December 30, 2020

This Letter of Intent shall serve as formal written notice of my request for Special Use for a Detached Accessory Living Quarters for permanent housing for a family member at the location of 3575 Harmon Drive, Monument, CO 80132.

3575 Harmon Dr  
Monument, CO 80132  
Scale: 1"=50'

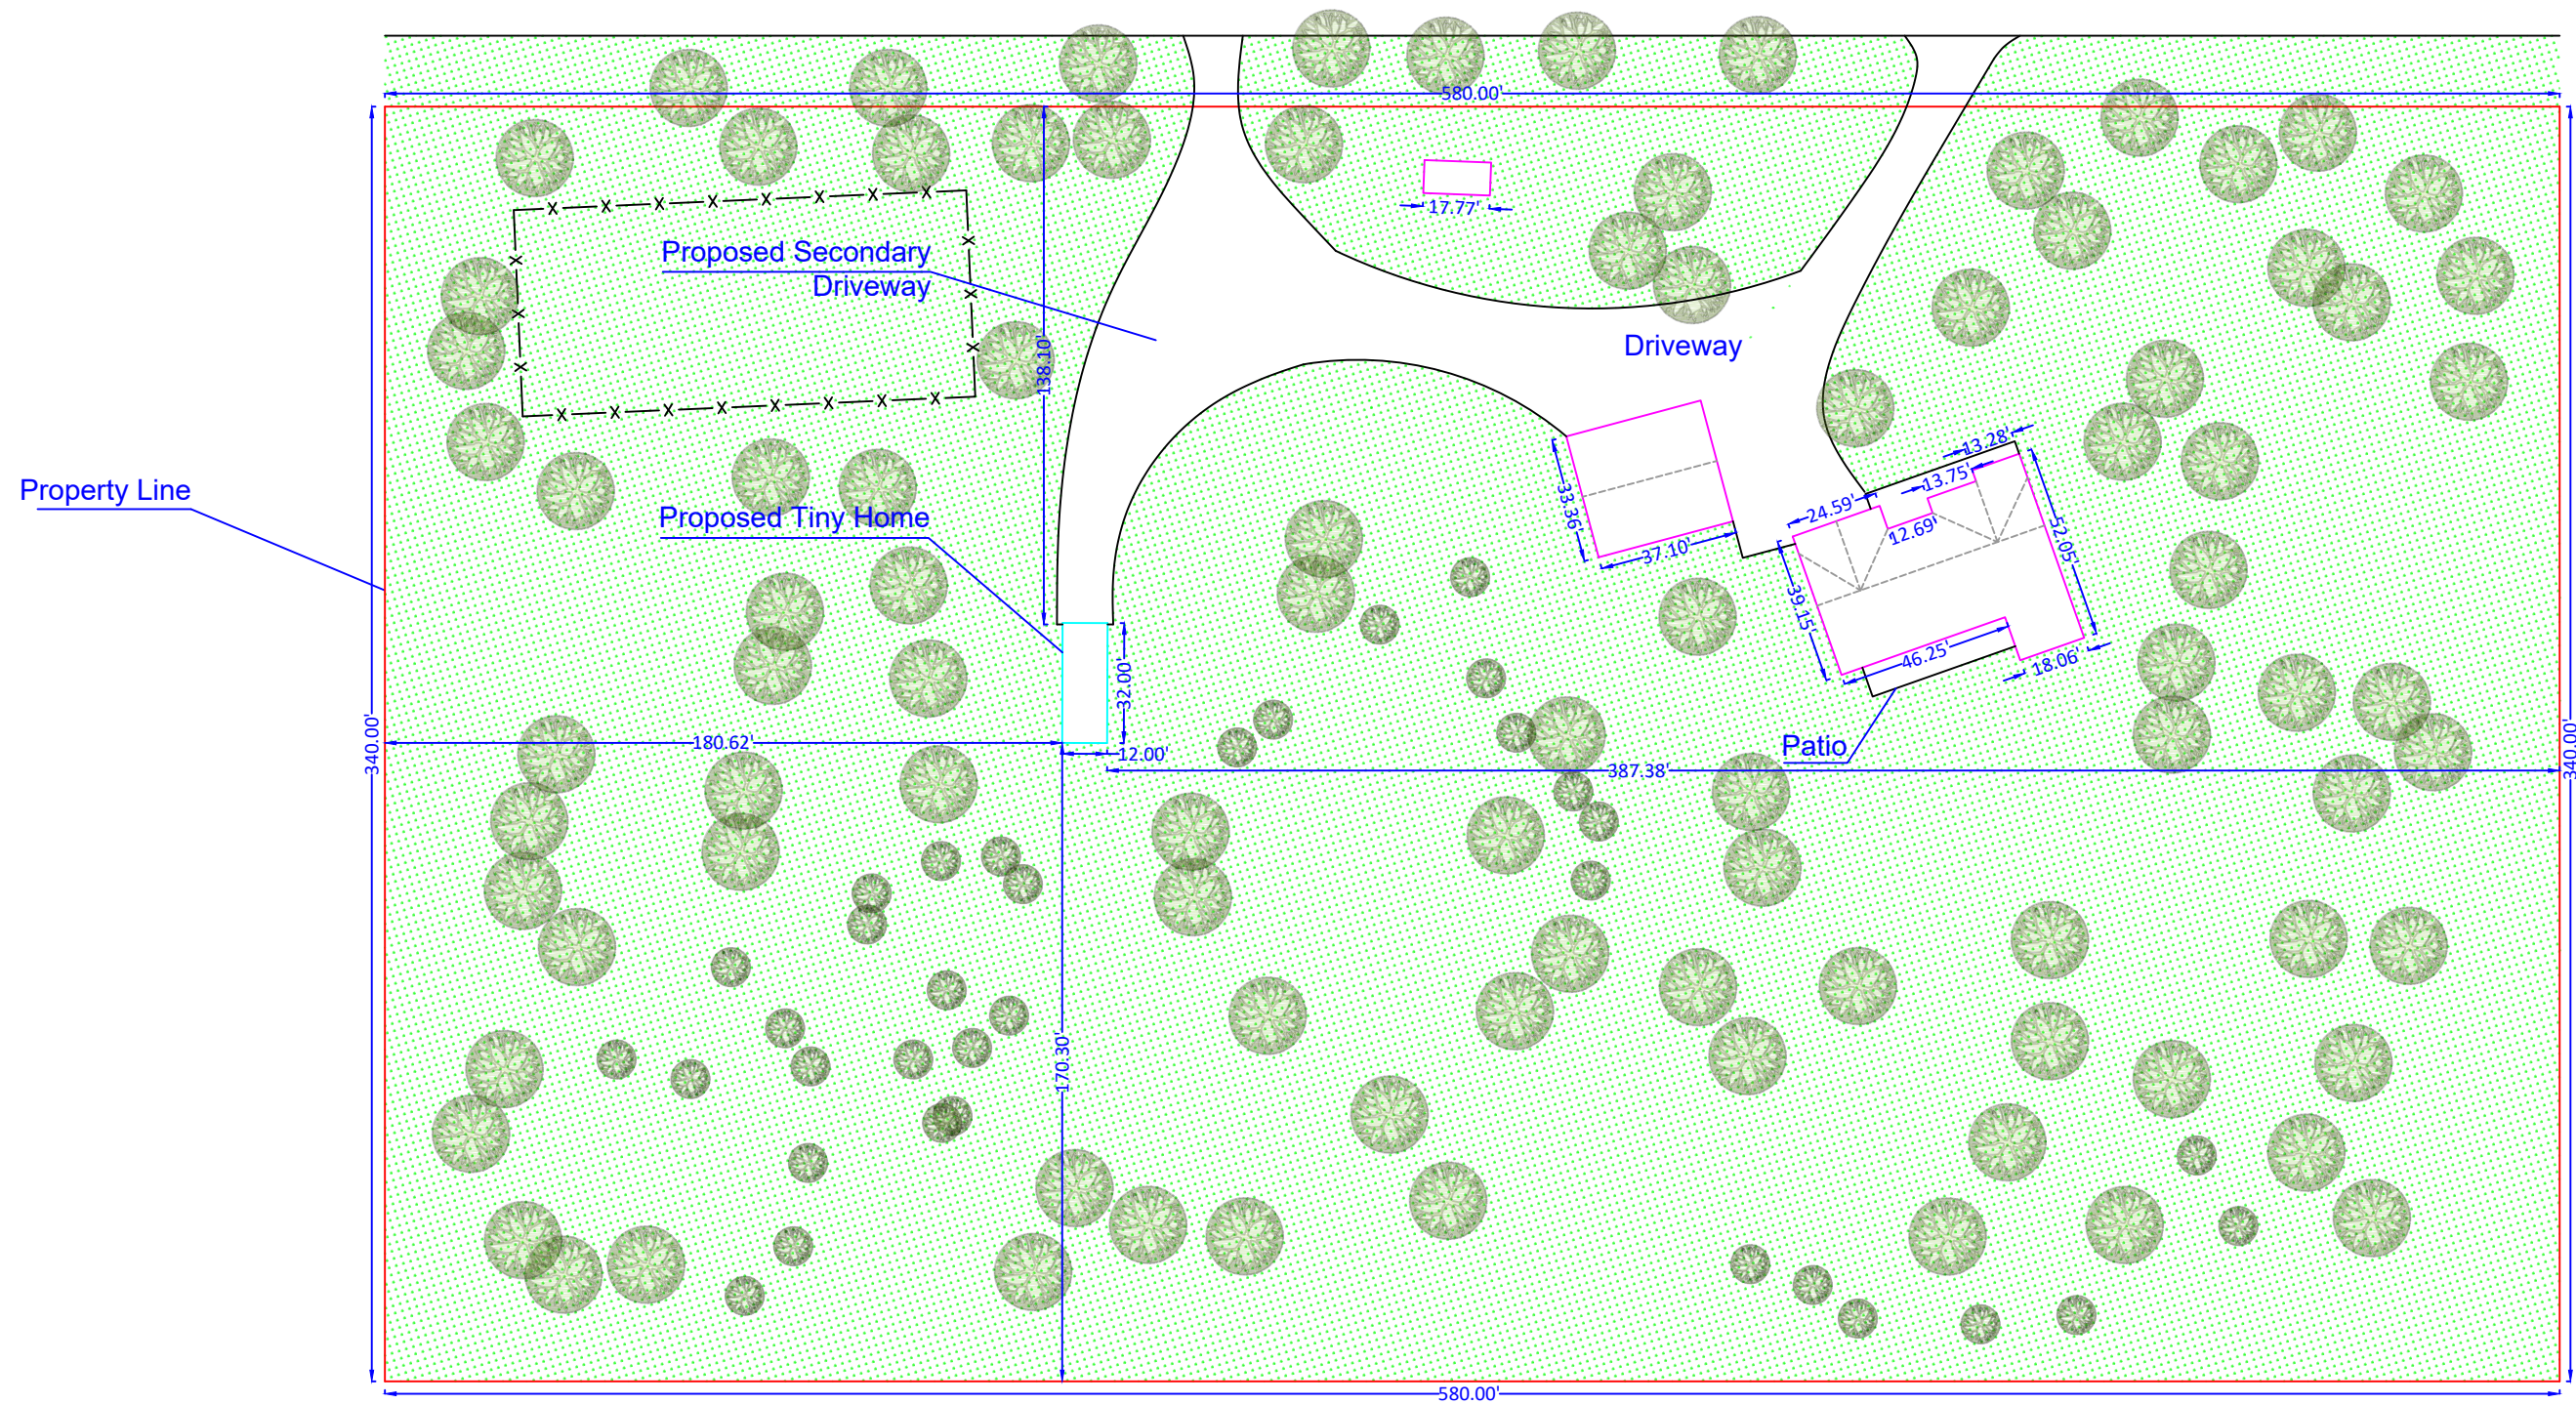
Please call out the driveway access permit for this driveway
